From: Martyn White
Sent: 07 December 2018 16:06
To: Planning.Responses
Cc: Richard Castro-Parker
Subject: BR/290/18/PL

BR/290/18/PL

Removal and replacement of all existing windows and doors to front, rear and side elevations from double glazed timber to UPVC windows & doors to match the existing in profile & pattern.

DRAWING: 0005_WH_PA_05 - EXISTING AND PROPOSED WINDOW DETAILS
DATE: FEB. 19 DRAWN: WM SCALE: 1:20@A1

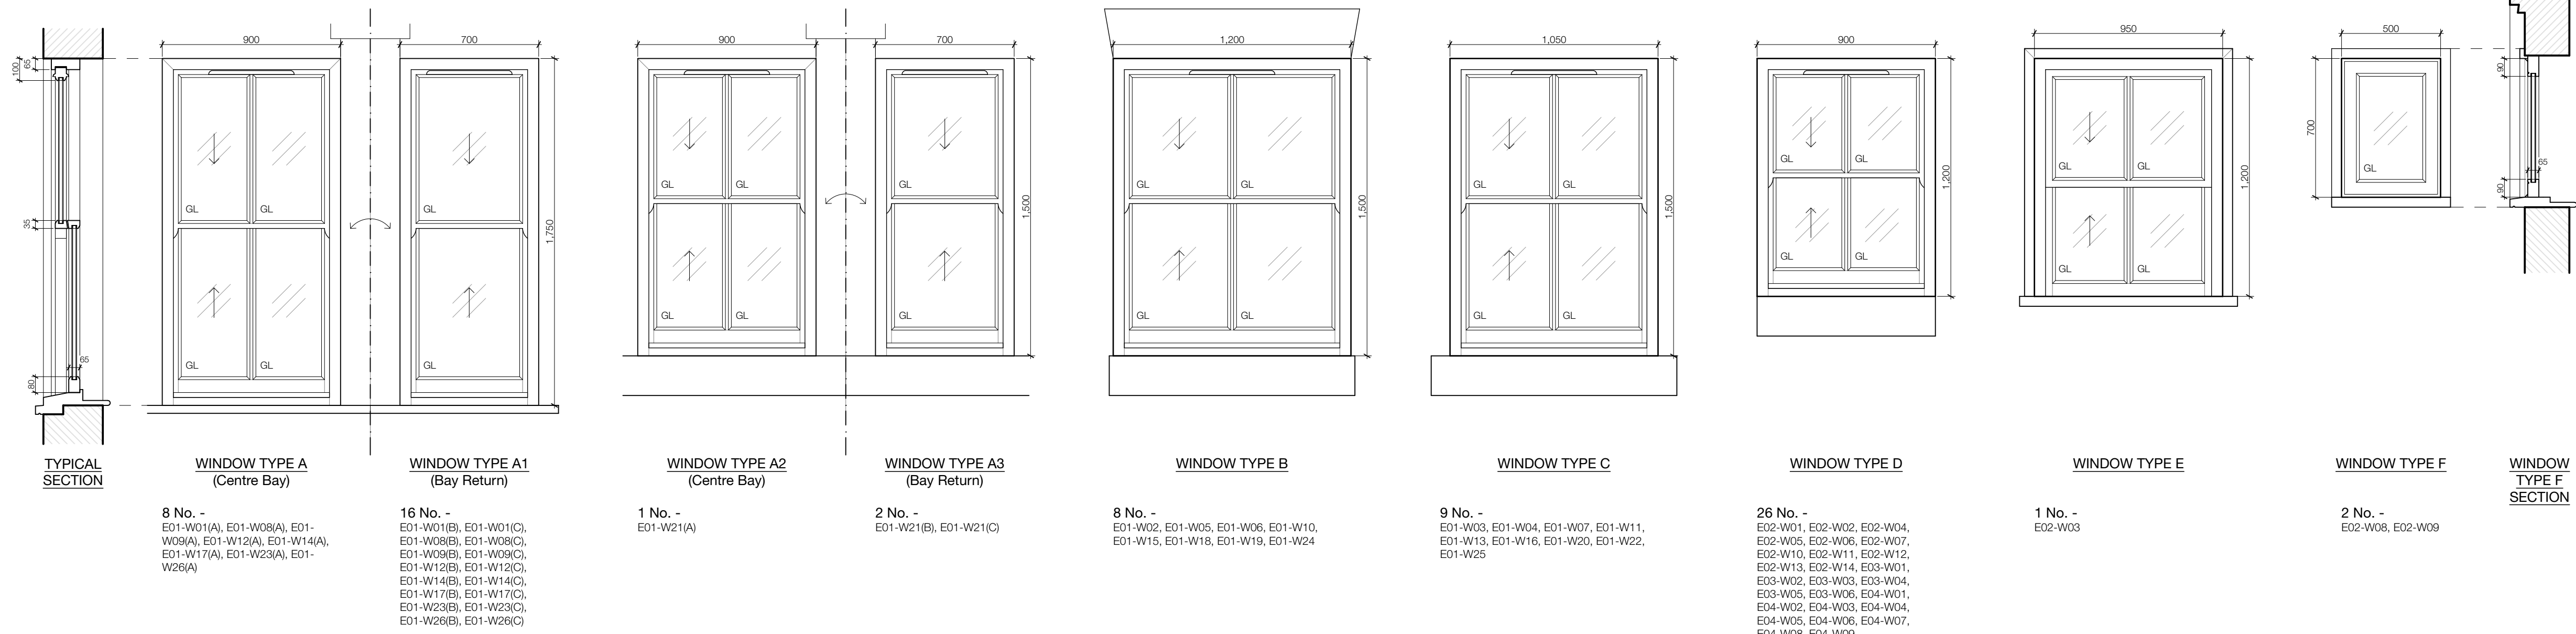
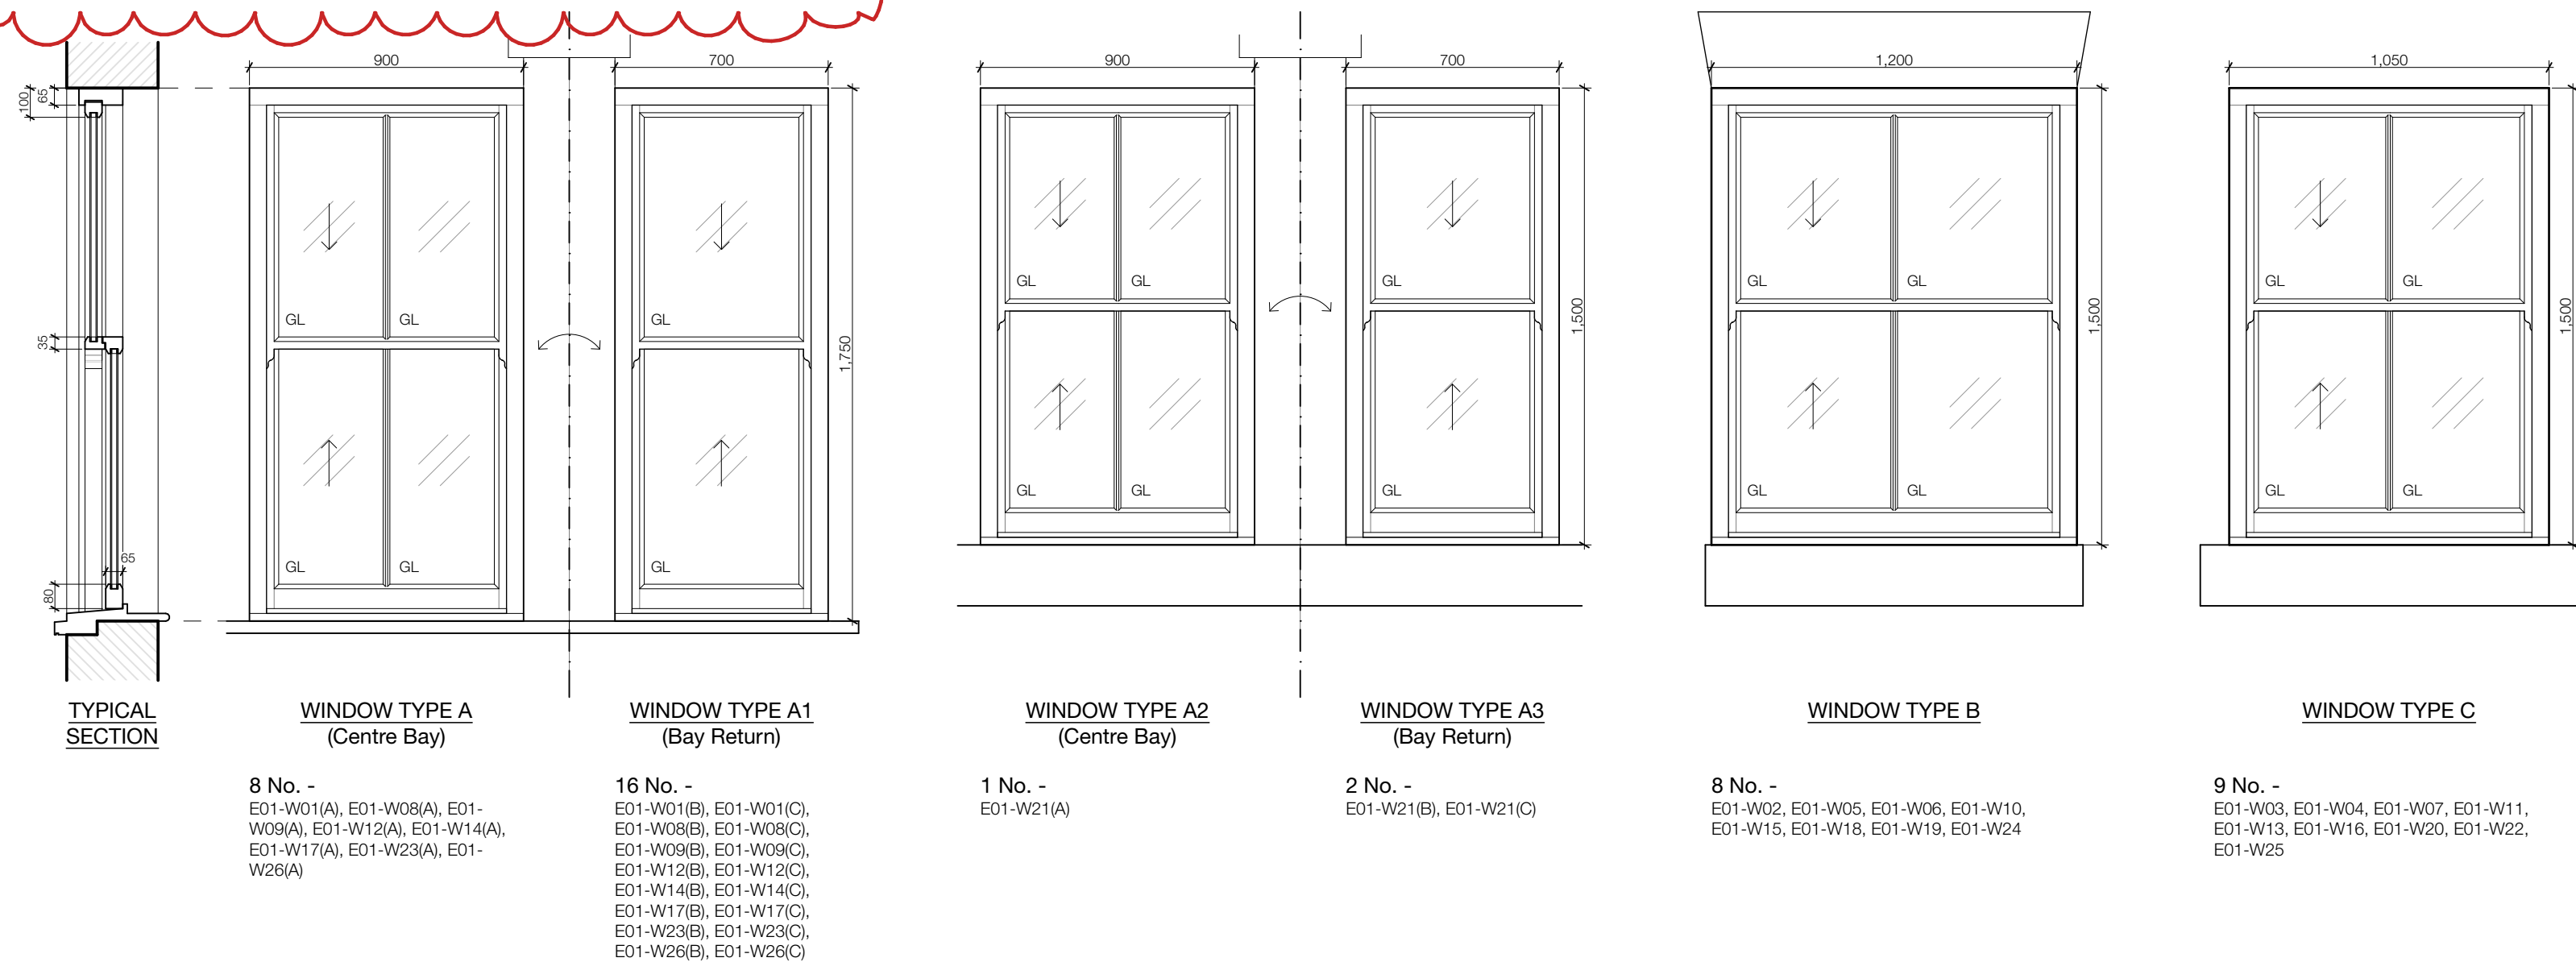
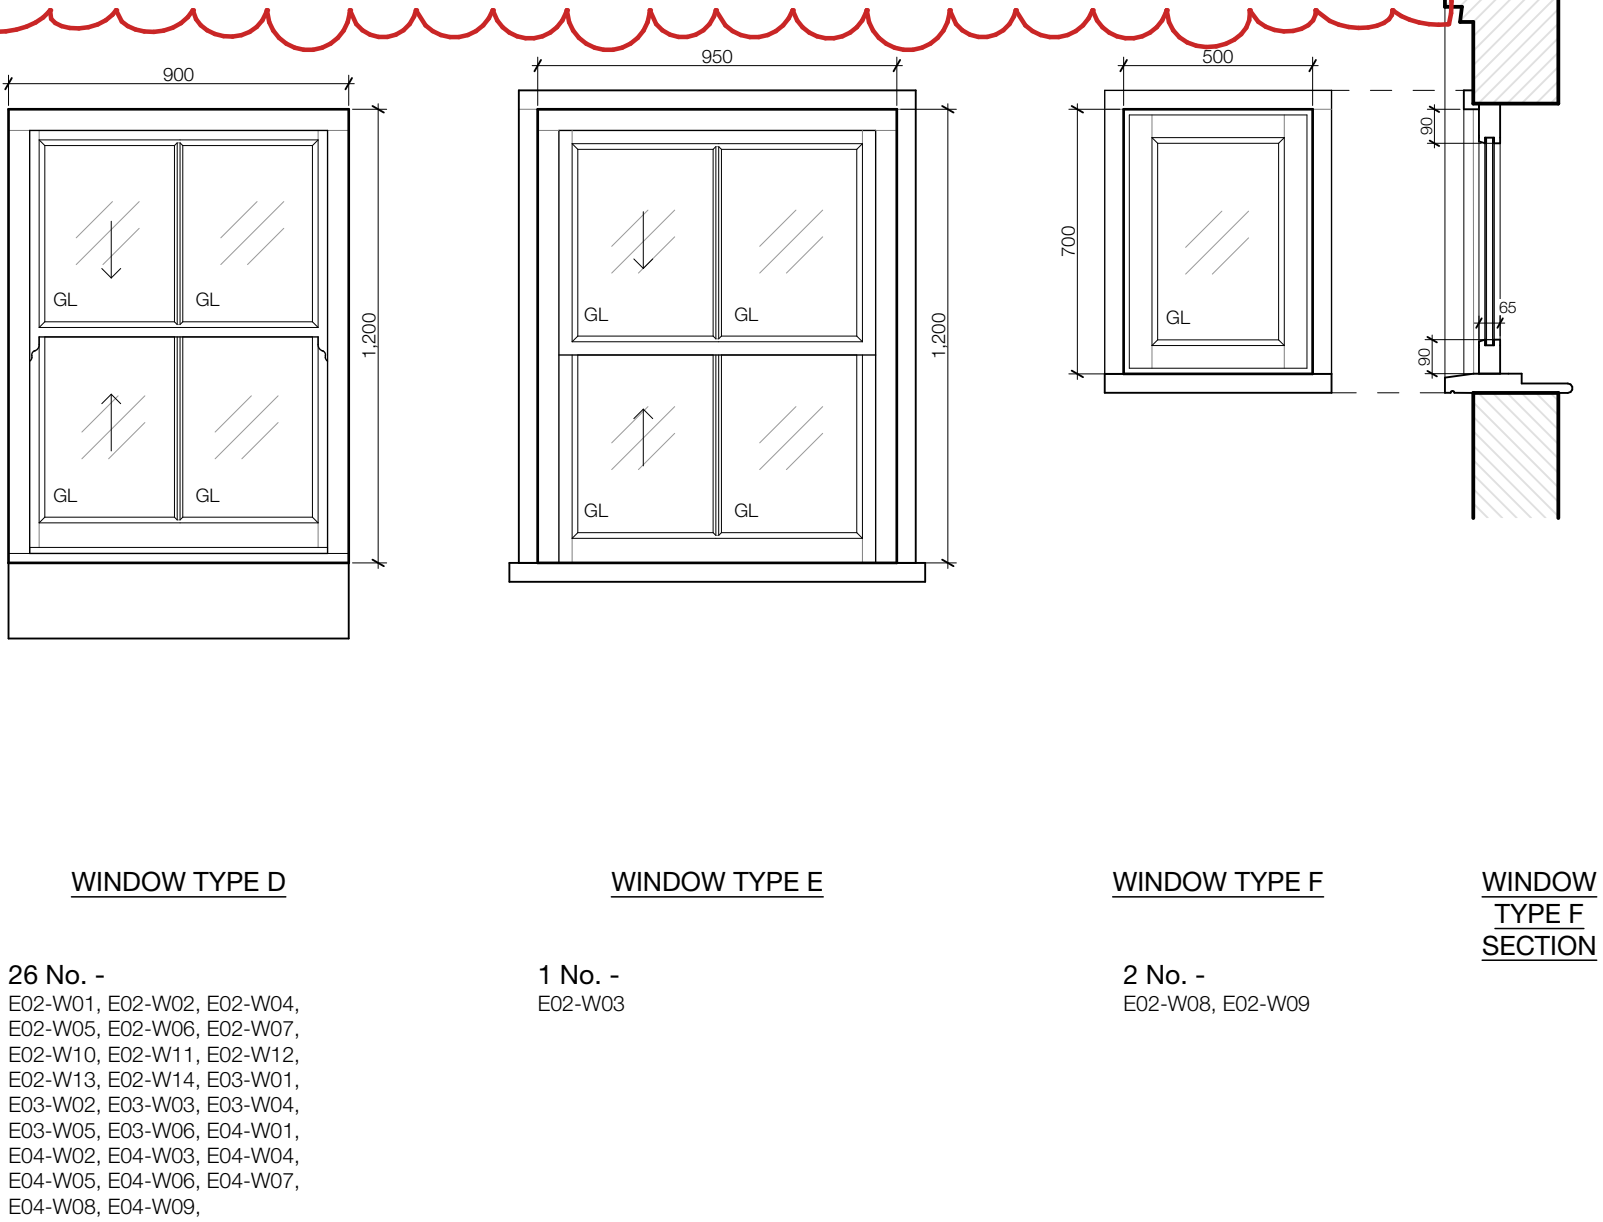
Normally within Conservation Areas we try to support the use of traditional materials, such as wood, as this respects the character of the area and the buildings within them. This is especially true of those windows which face on to the public realm. As a consequence, any new windows should reflect the appearance/materials of those currently installed in the building.

It is considered that based on the information provided, that the windows proposed to be used appear to reflect the general appearance of those currently present within the building.

Whilst an explanation has been provided as part of the application, it is not considered that it adequately justifies why the existing windows cannot be replaced on a like for like basis. As a consequence, my preferred approach would be to use traditional materials to the public facing elevations of the property.
